Rezoning Transportation Analysis

Petition Number: 2020-122

Revision Log:

Date	Description
09-14-20	First Review
10-19-20	Second Review

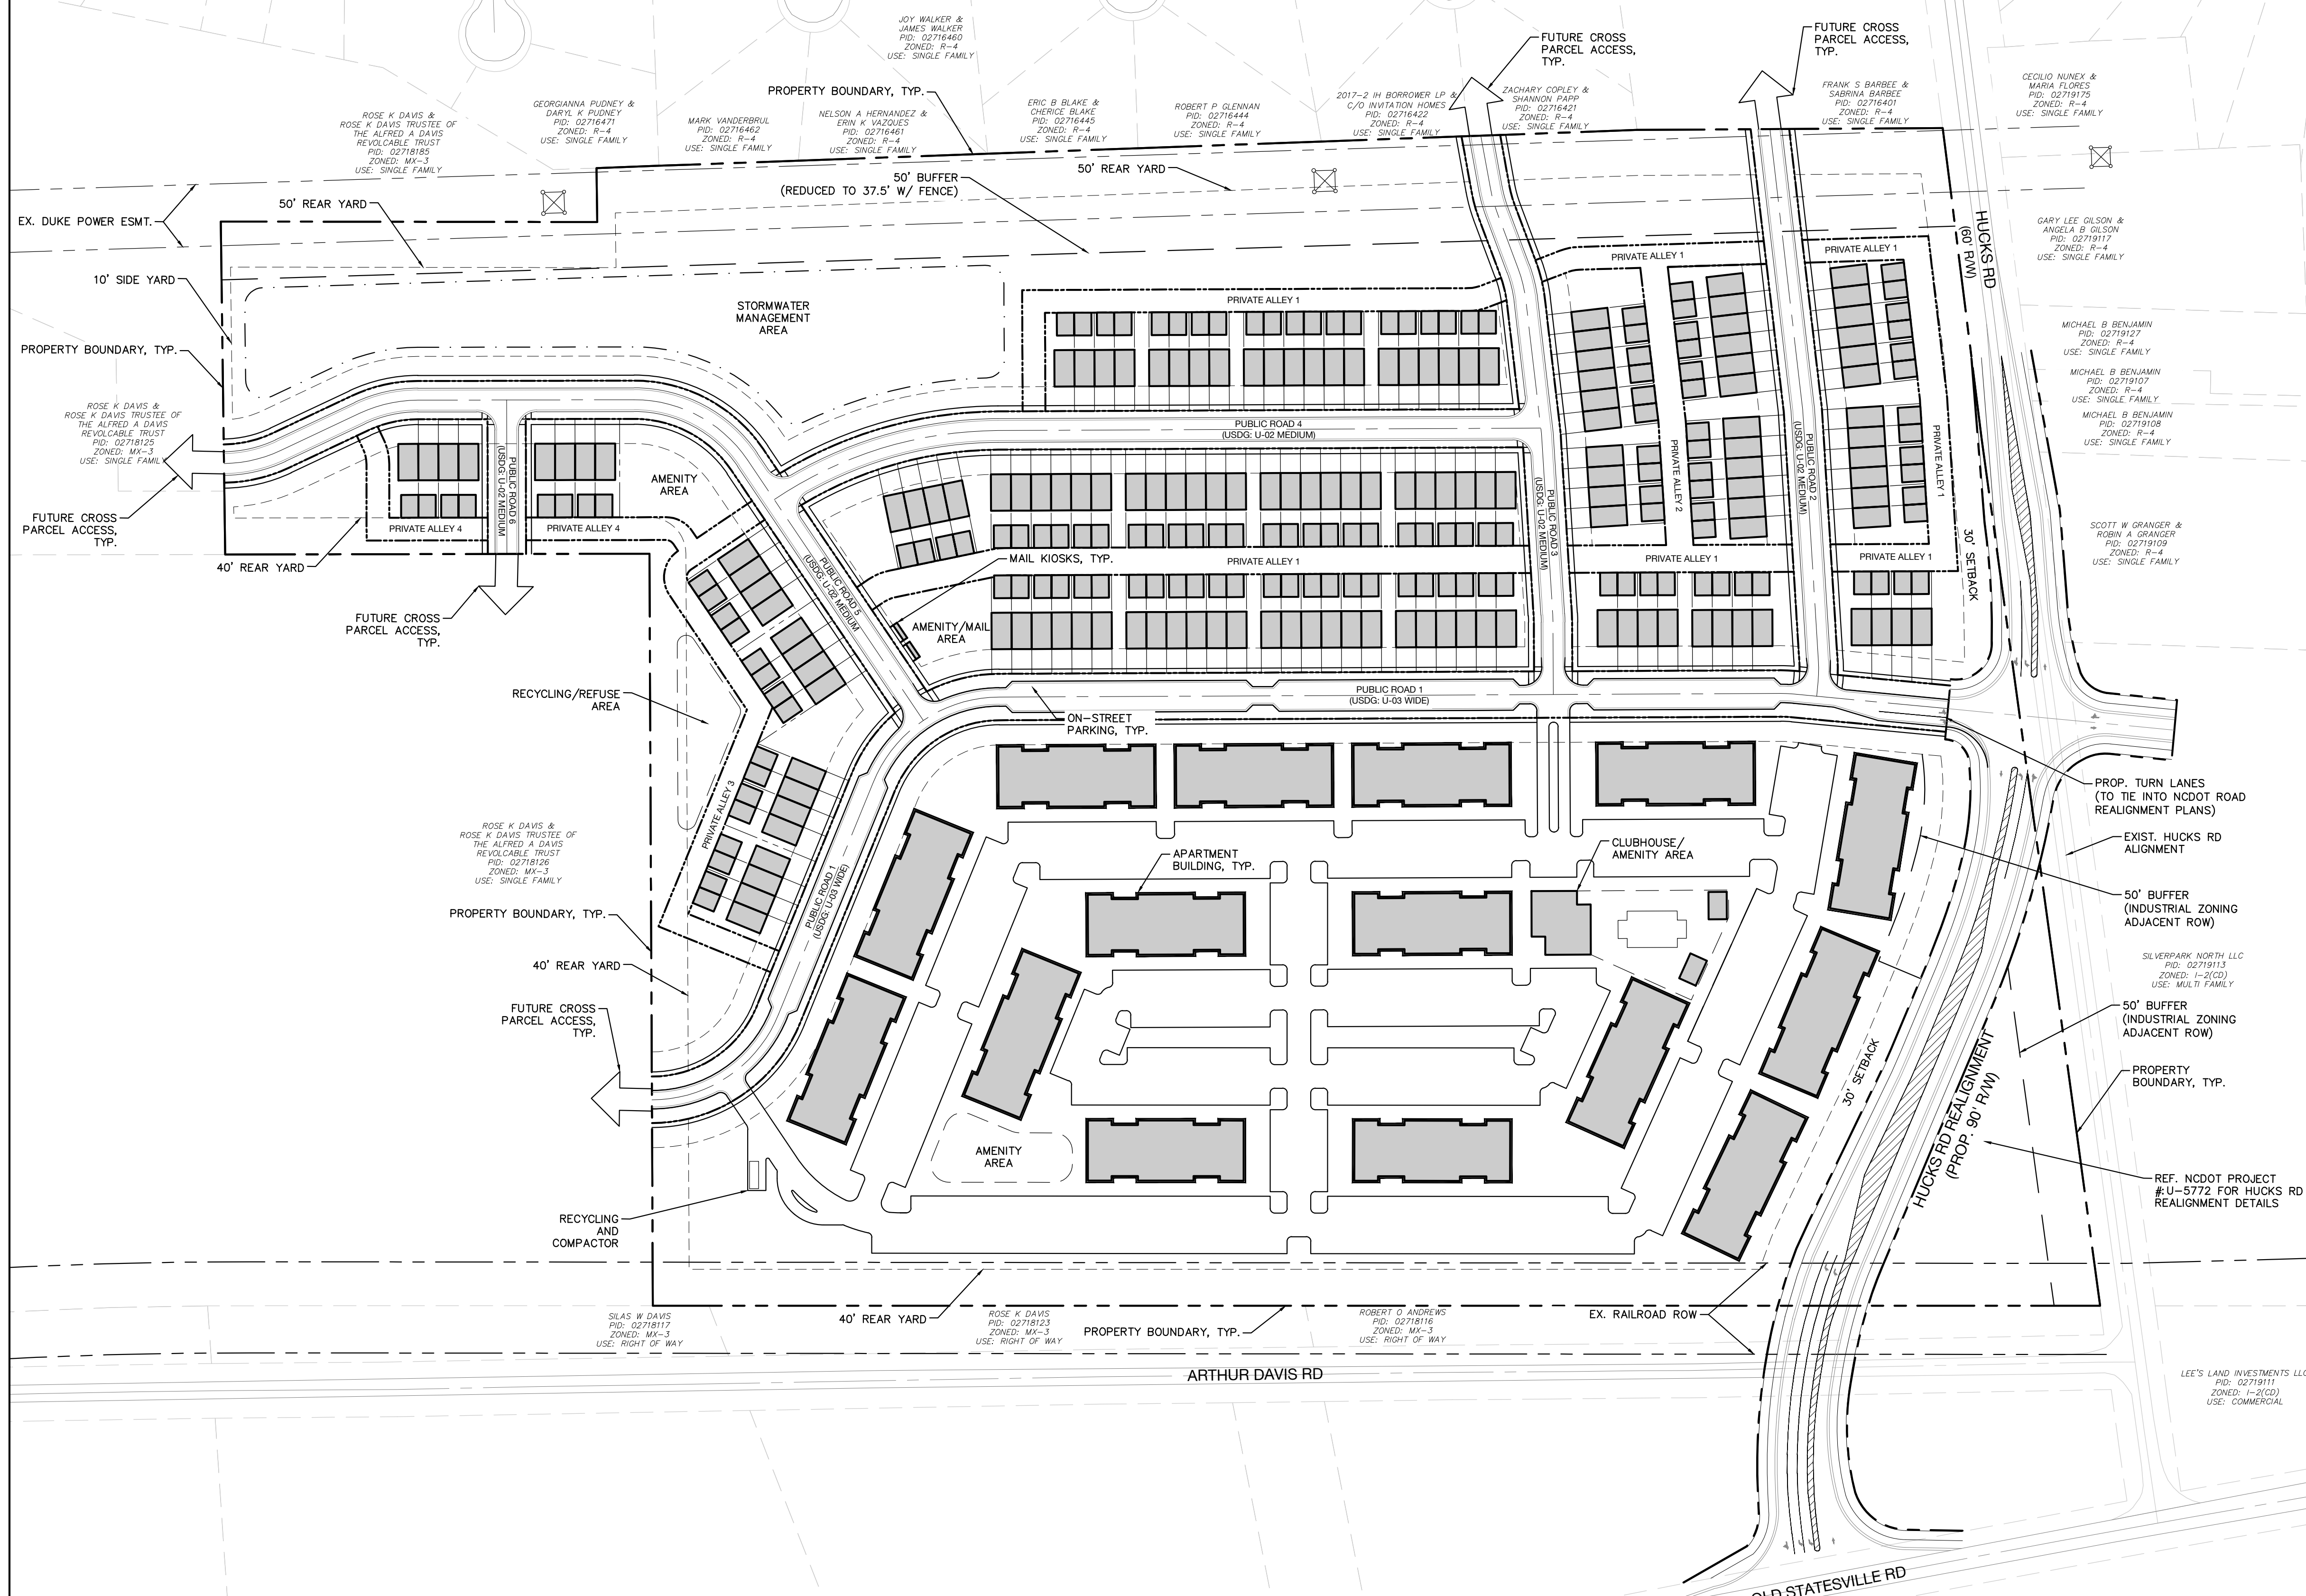
- Outstanding (site plan dated 10.12.20):** Revise the site plan and conditional note(s) to commit to construct Hucks Road Realignment cross section as in the approved TIS scope. In lieu of a raised, curbed median island, install asphalt and a striped median instead. This will ensure that CFD can safely maneuver through the area. Construct the multi-use path as per CLDSM standards.

- Outstanding (site plan dated 10.12.20):** Revise the site plan and conditional note(s) to commit to dedicate right-of-way for the Hucks Road Realignment, labeled and dimensioned for the total right-of-way dedication width.

- Outstanding (site plan dated 10.12.20):** Revise the site plan and conditional note(s) to commit to construct the portion of Hucks Road Realignment that is graphically depicted on the site plan sheet **RZ-1.0**, to match the approved TIS scope.

- Outstanding (site plan dated 10.12.20):** Revise the site plan and conditional note(s) to include the roadway improvements that are required within the final approved TIS.

9. **Outstanding (site plan dated 10.12.20):** Submit a [Right of way Abandonment Petition form](#) to CDOT for review of the potential abandonment of existing Hucks Road, with the commitment to construct the portion of Hucks Road Realignment, as shown on the site plan dated **7-10-2020**. The decision of this rezoning petition does not correlate with the decision of the possible abandonment, as this decision is issued within the separate Right-of-Way Abandonment process that is controlled by North Carolina General Statutes.
